DECISION DELEGATED TO HEAD OF PLANNING

Application No: H23-0365-26 **Applicant:** Mr & Mrs Stimson
Proposal: Single storey rear extension
Location: 2 Pipwell Meadows Saracens Head Spalding
Terminal Date: 12th June 2026

CASE OFFICER ASSESSMENT

Proposed Ground Floor Plan
Proposed Elevations
3D View

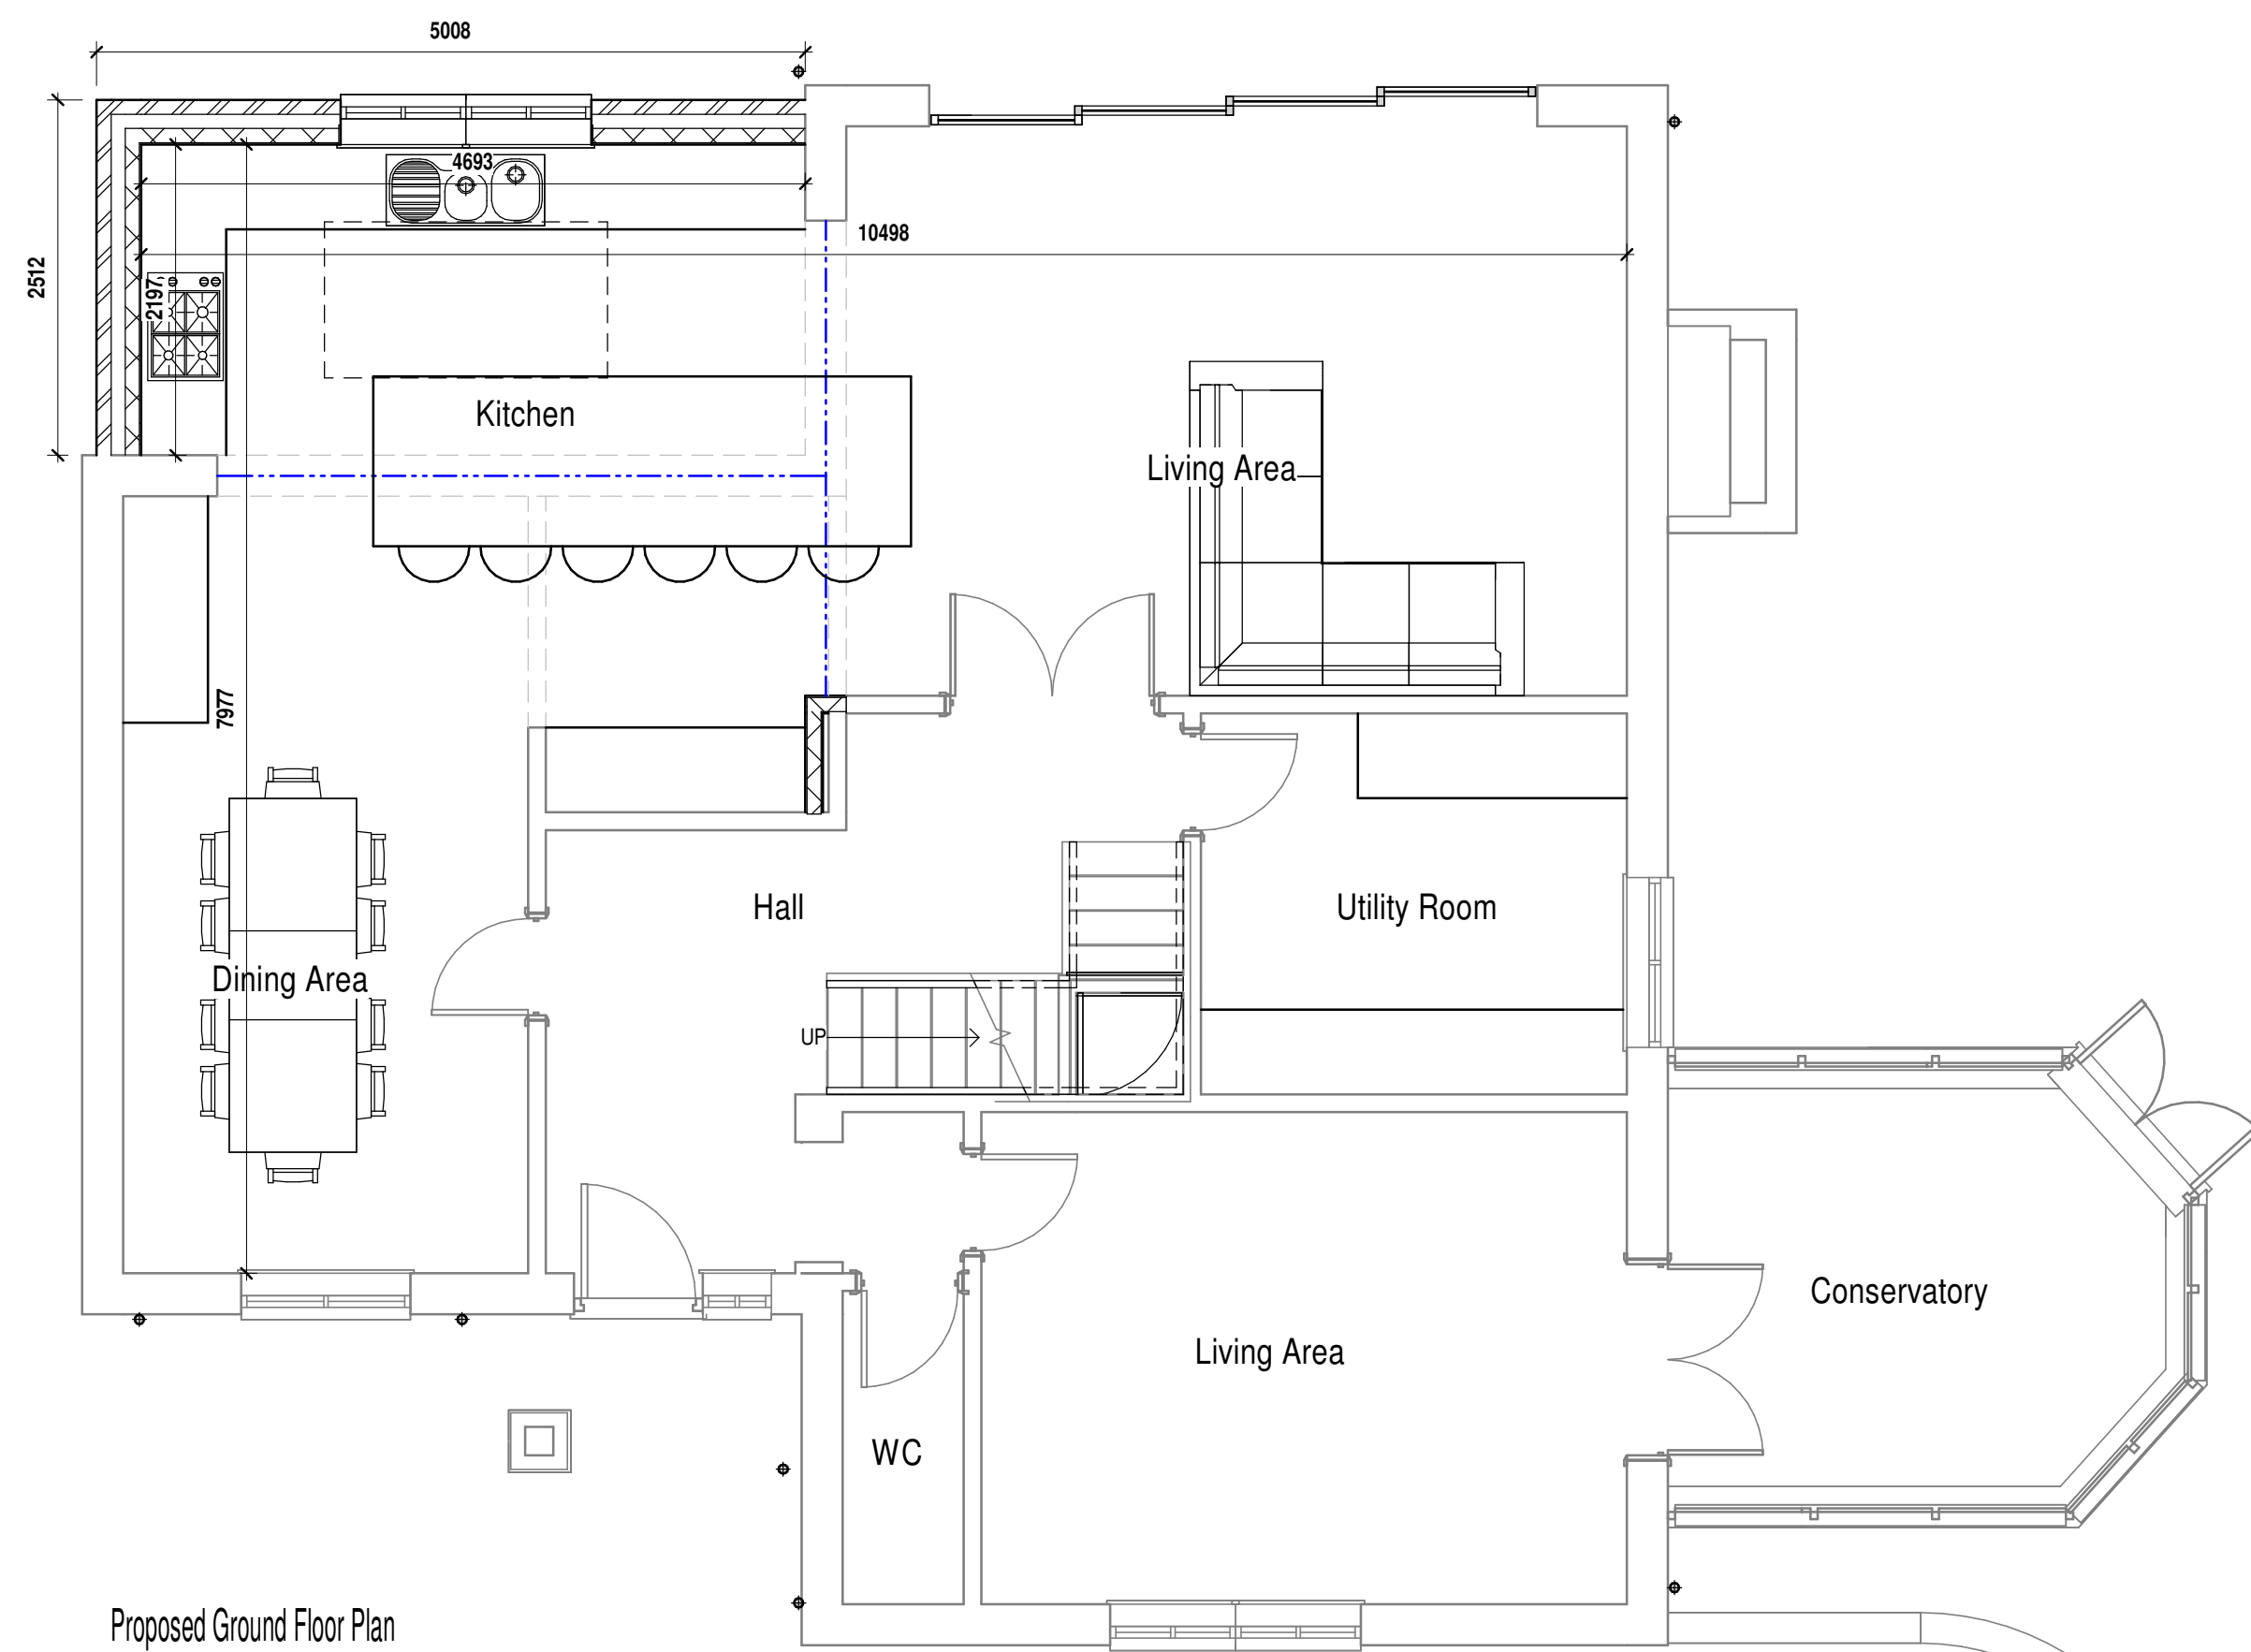
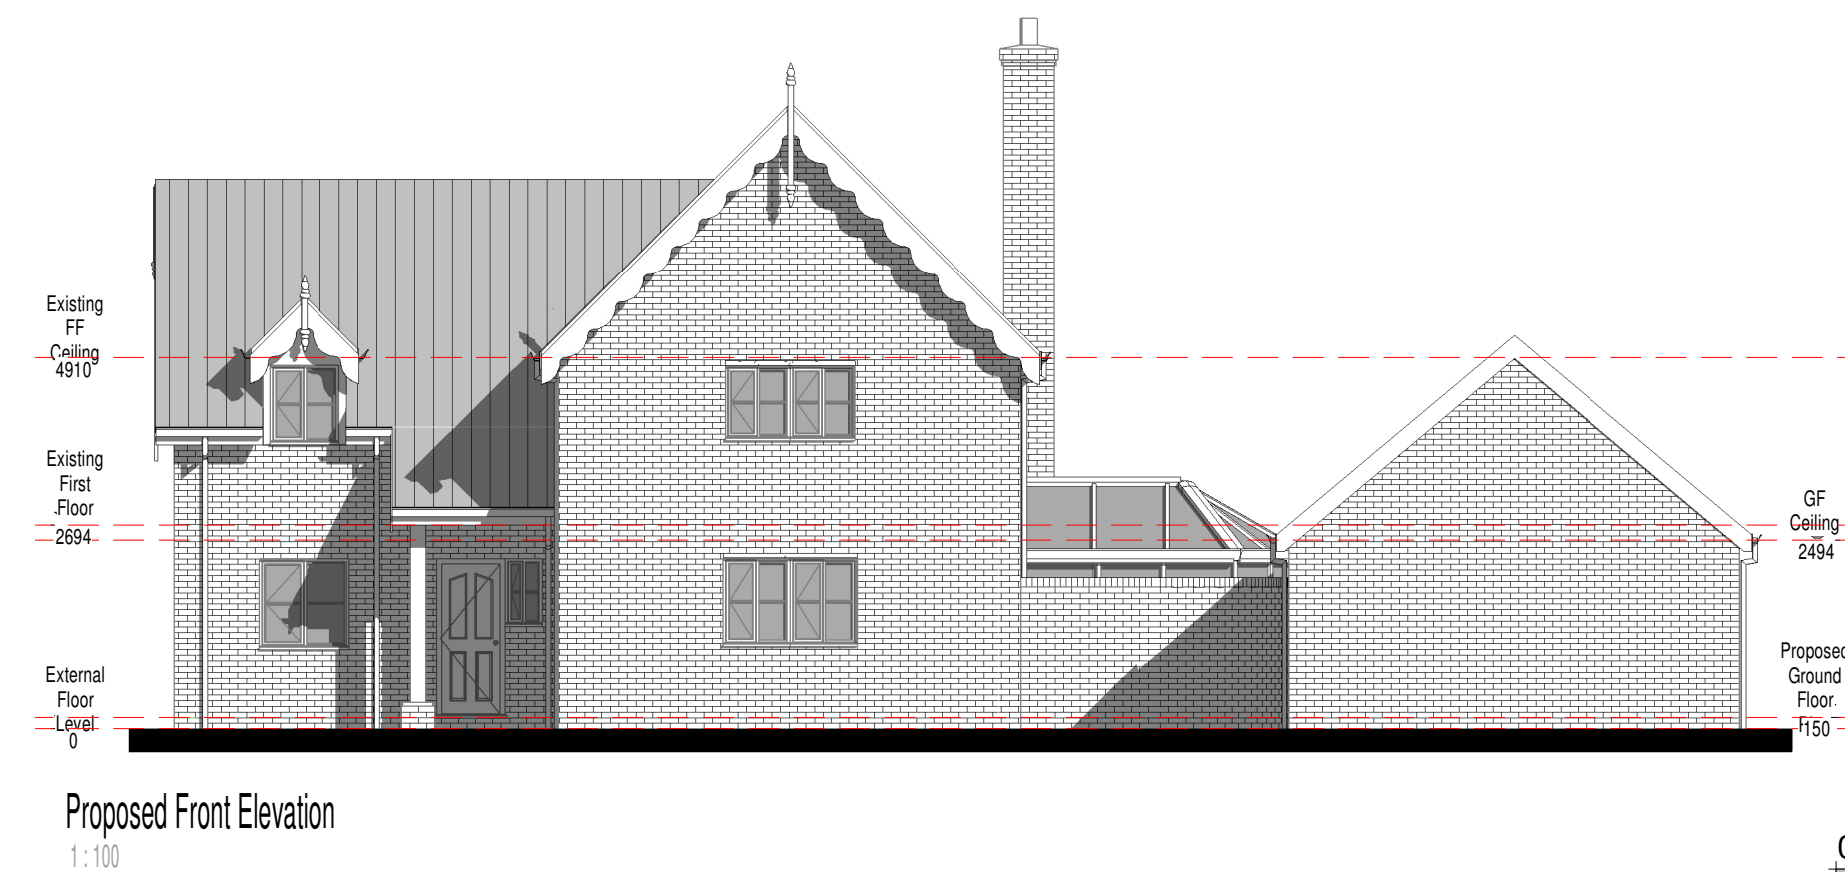
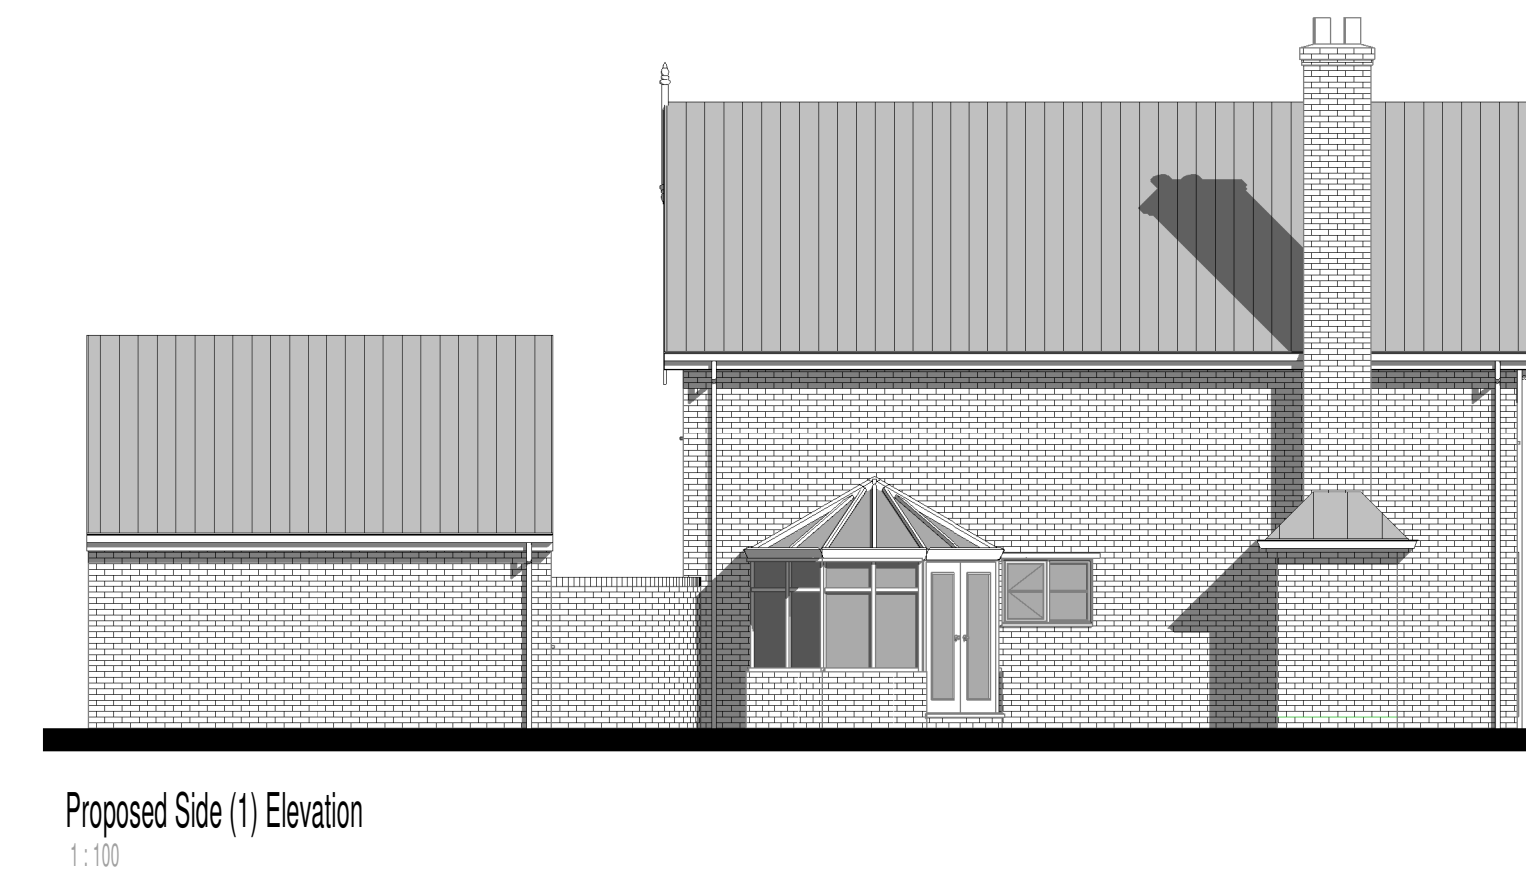
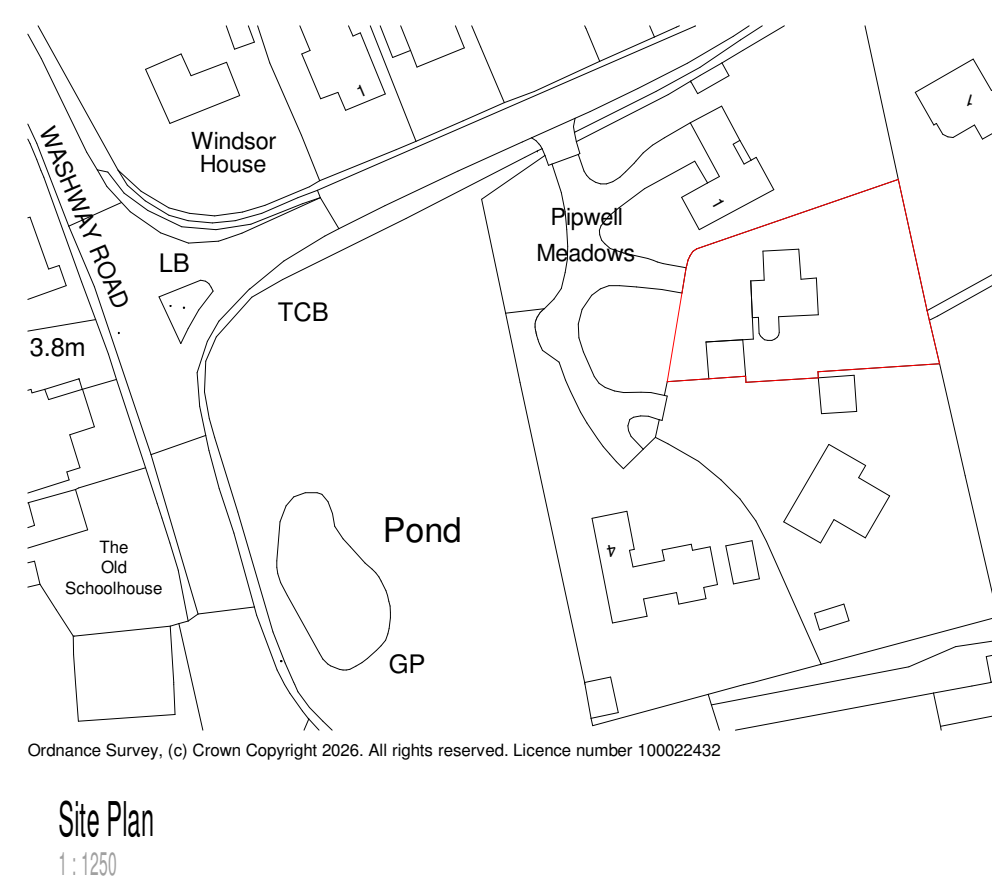
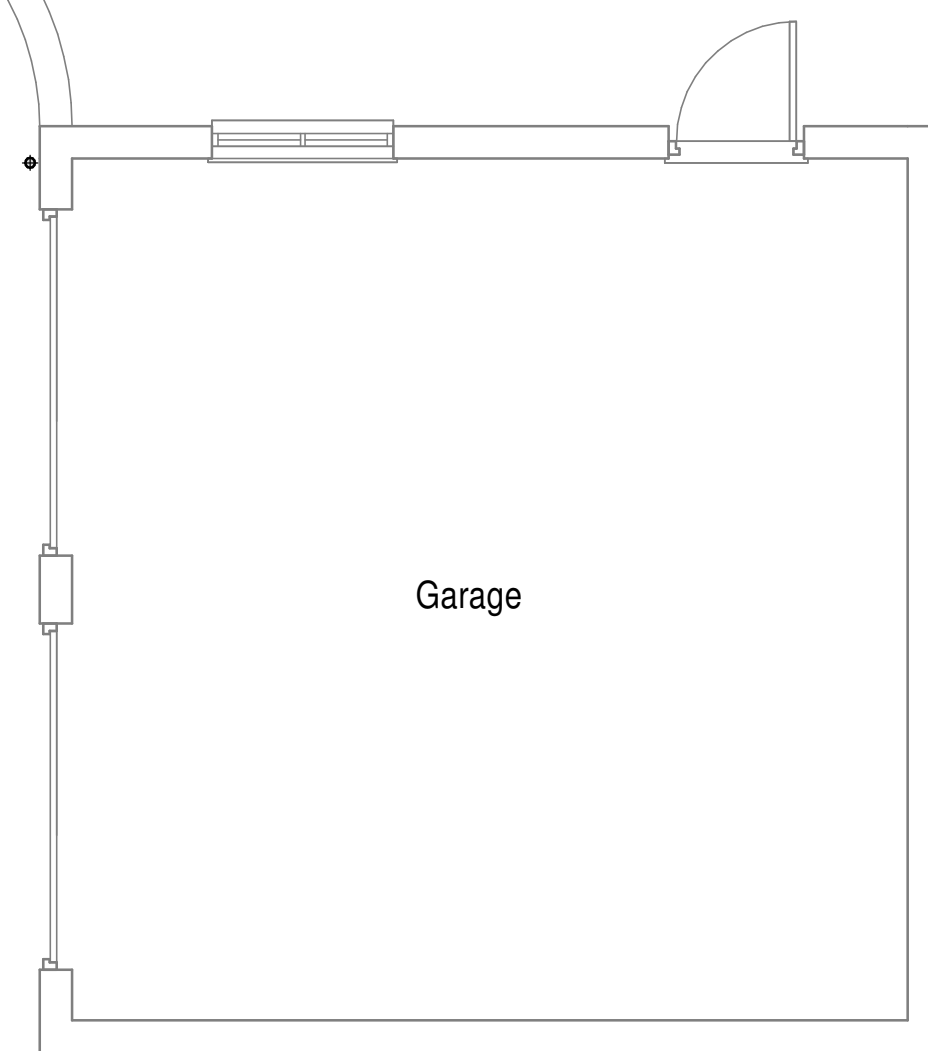
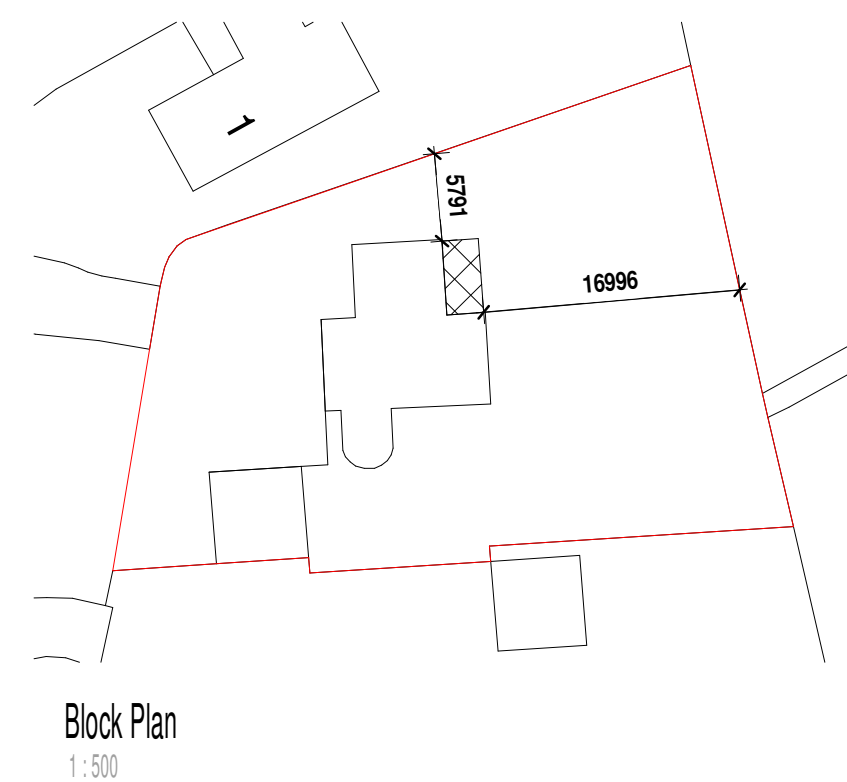
The height of the extension is 2.9m and the height of the eaves on the existing dwelling vary. According to Permitted Development Rights for Householders Technical Guidance (2019):

The highest level of the eaves on the existing house is approximately 5.2m. Therefore, the eaves of the extension would not exceed the height of the eaves of the existing dwelling.

The proposed extension would not conflict with part f as the extension measures 2.5m from the original rear elevation.

The proposed extension would not conflict with part g as the extension measures 2.5m from the original rear elevation (thereby not exceeding 8 metres) and 2.9m in height (thereby not exceeding 4m).

The proposed extension would not conflict with part j. The proposed extension would extend outwards from one of the side elevations of the original dwelling; however, the width of the original dwelling is 11m and the extension is proposed to be 5m in width. As such, the extension would not extend more than half the width of the original dwelling.

The submitted plans do not show the proposed materials; however, the submitted application form sets out that the materials used will match the existing dwelling, thereby complying with part a.
